Please ask for: Kathryn Welch
Email: kathryn.welch@arun.gov.uk
Telephone: 01903 737789
Our Ref: M/12/21/T
Your Ref:
Date: 5th February 2021

Town & Country Planning Act 1990 (as amended)
Town & Country Planning (Tree Preservation) (England) Regulations 2012

Application for Works to Trees(s) subject to a Tree Preservation Order(TPO)

Development: Remove limbs to 2 No. Sycamores (T1 and T2) to westerly face.
Location: 14 Sunnymead Close Ancton Middleton-On-Sea PO22 6LS

Location of the two
Sycamores.

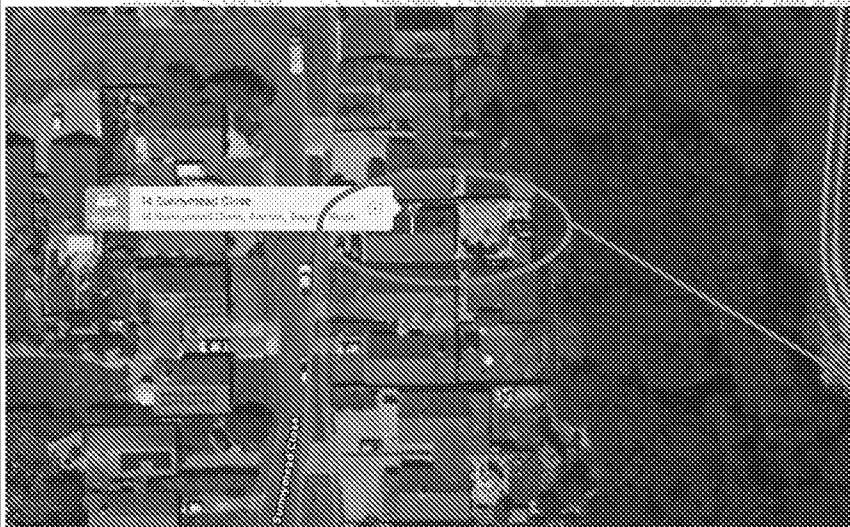
Please provide proposed height measurement (m) of canopies from ground level of T1 and T2 to westerly faces.
